COMMENTS ON RESPONSES TO EXQ1 DEADLINE 2

BY ANNE HEARD (Interested Party Reference 20054475)

Drawing number	Revision number	Drawing title	Scale
<b>Figure 2.1</b>	01	Environmental Considerations	A3
<b>Figure 2.2</b>	01	Existing Public Rights of Way	A3

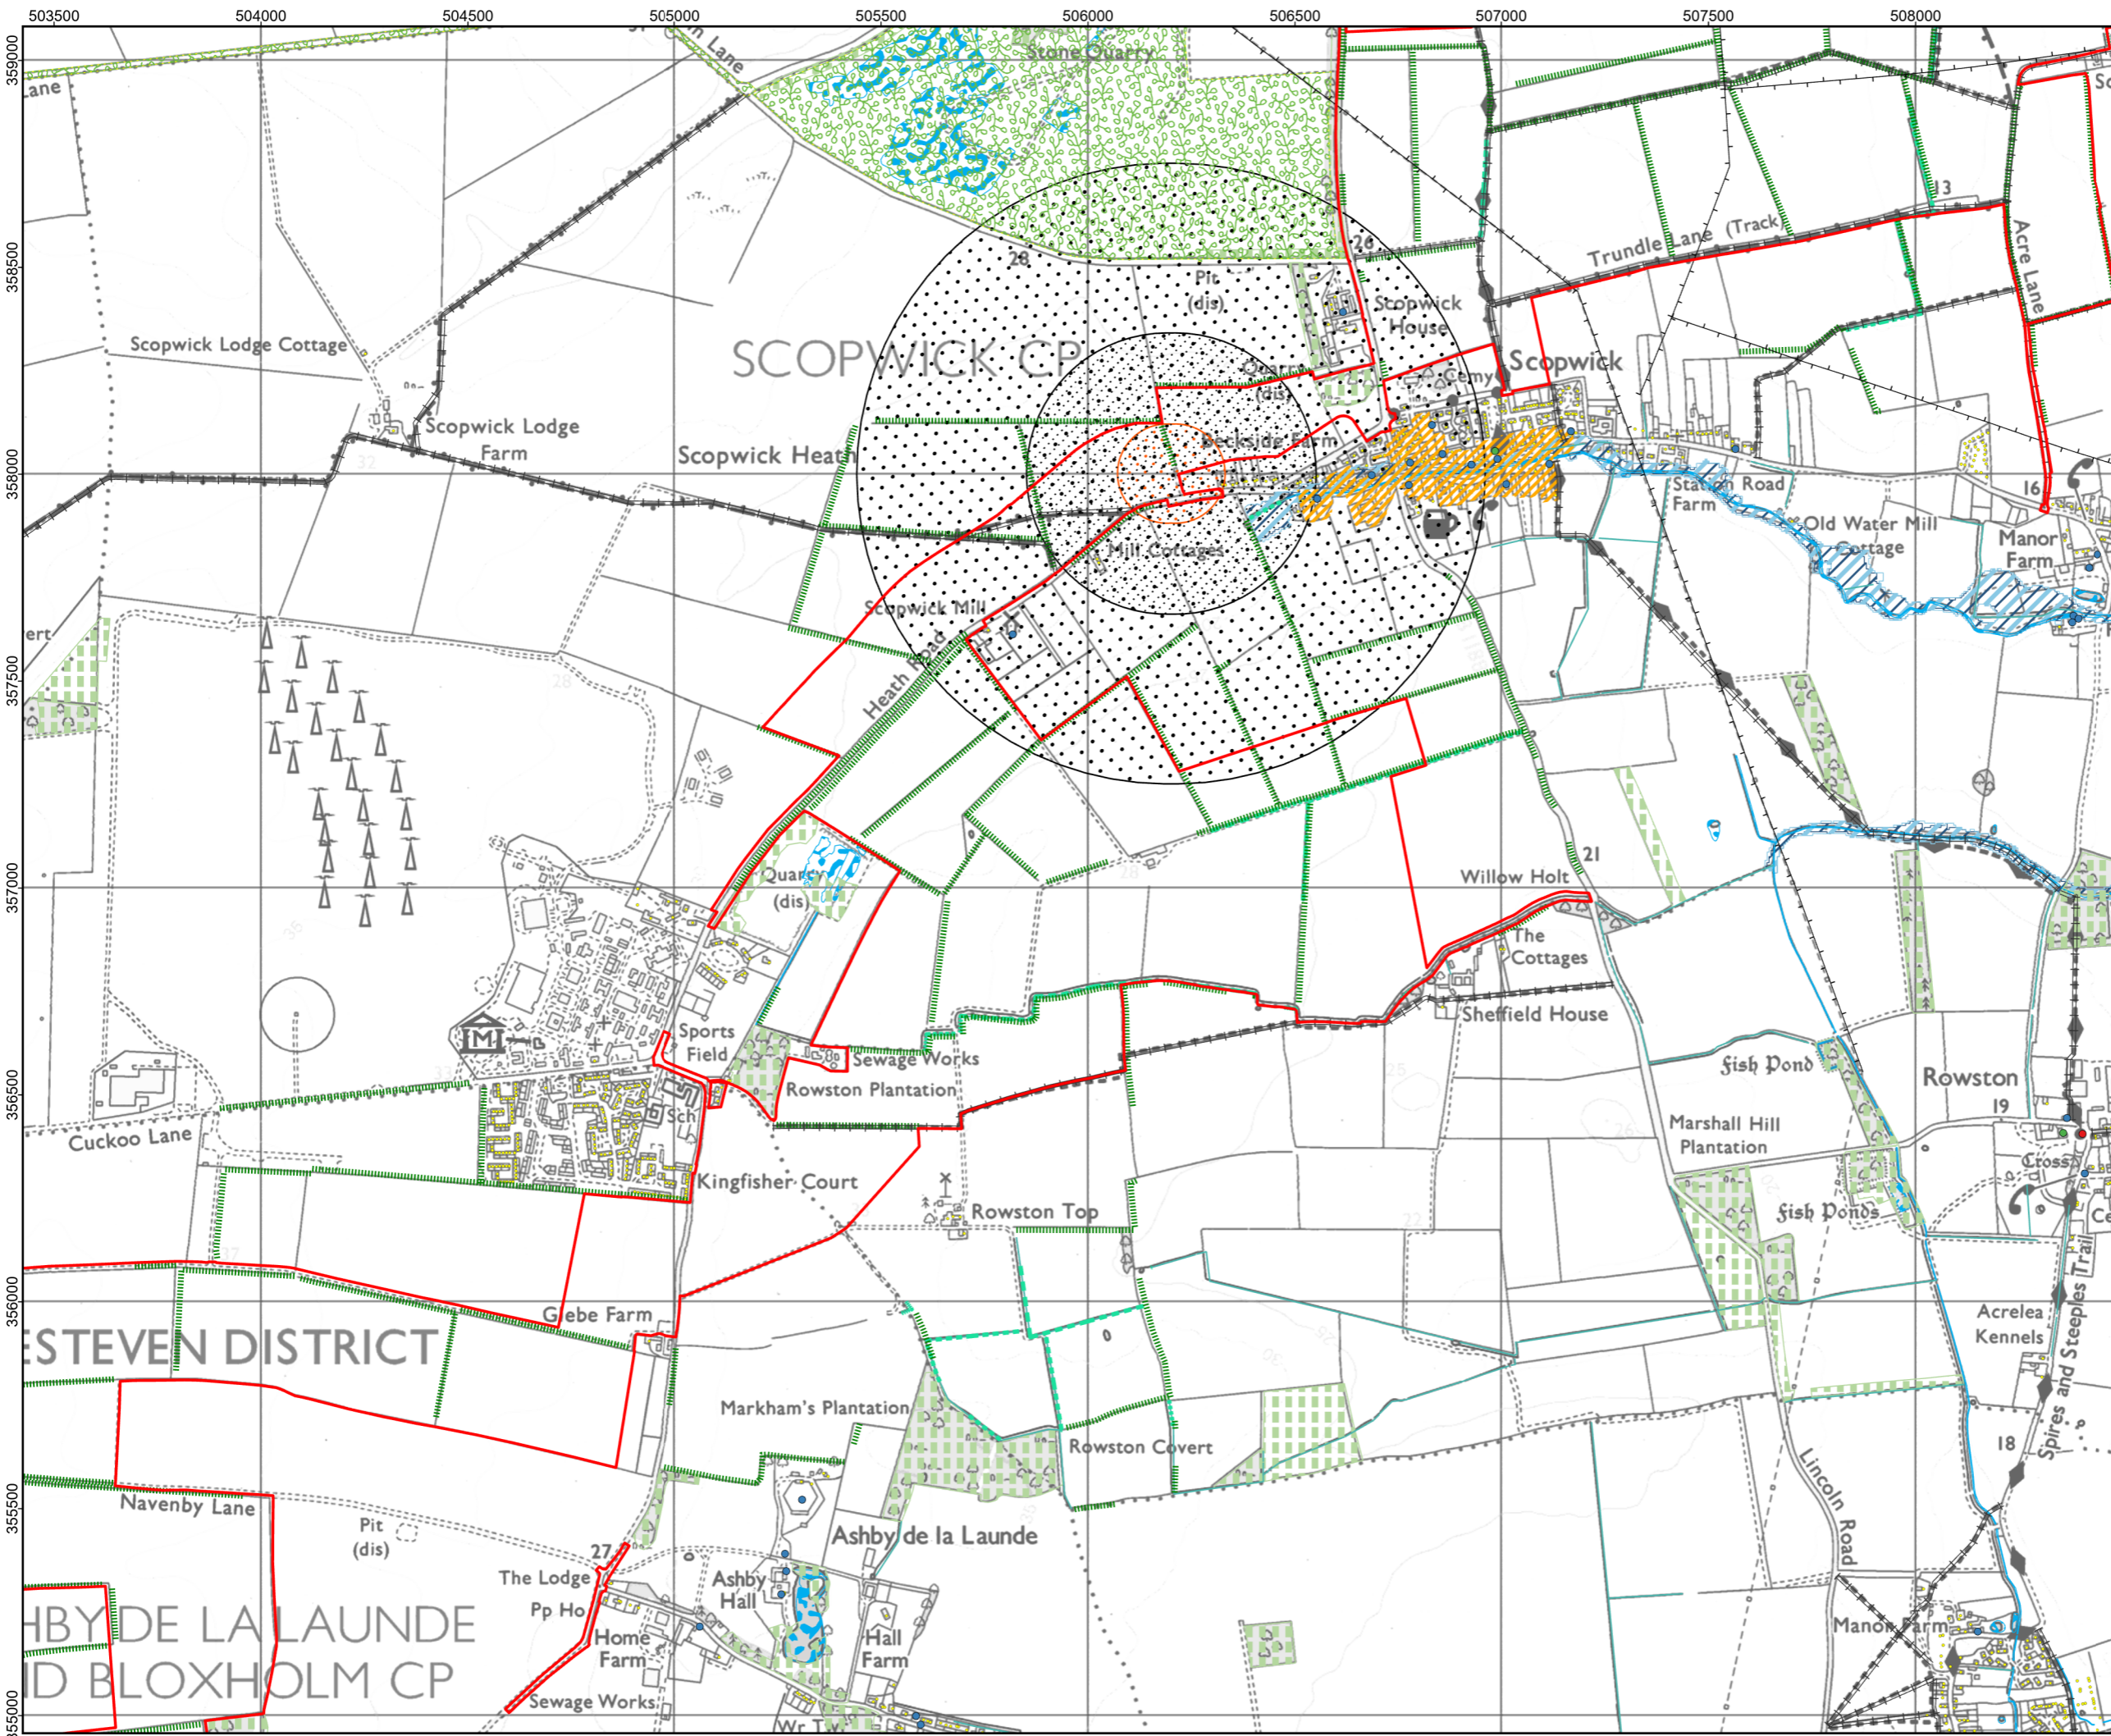
26. The Applicant then goes on to suggest that users of the PRoW would be likely to experience noise levels above the ambient “for a matter of minutes”. In an attempt to demonstrate that the Applicant has understated the magnitude of the likely effect of noise on PRoW users, I set out below details of a walk I took along the public footpaths around Scopwick on a rainy cold February day this year. The route of the walk is shown with a red line on the plan below:-

27. I walked north along Scop/10/1, then turned east along Scop/10/2, then north along Scop/11/4, then west along Scop/1135/3 and Scop/1135/3 and finally south along Scop/737/1, a walk of approximately 2.5 km which took me an hour as I stopped to take photographs. The points marked A,B, C and D on the plan are points from where I took photos as follows:-

Point A -Photograph looking north along the Steeples and Spires footpath (on the left side of the photo)

Point B- Looking east along Scop/10/2

Point C - The Junction of Scop 11/4 and Scop1135/4 looking west

Point D - On Scop/1135/3 looking north west across open fields

28. This route is well used, the track is worn (Photo at Point B) with evidence of use by people and horse riders. Whilst I was there during an early afternoon on a weekday in winter I met two groups of dog walkers. The fact of frequent use is borne out by the footfall evidence of the Stepping Out walks submitted by NKDC in their response to EXQ1 (REP1-103-Q1.12.3). This shows that during 2024/5 4903 people walked the Scopwick footpaths and 7205 walked the Blankney footpaths.

29. There are no built features which would attenuate any noise from plant and machinery along these footpaths, so any noise emitted from construction or operational activities would be heard over long distances and for longer than the “few minutes” described by the Applicant.
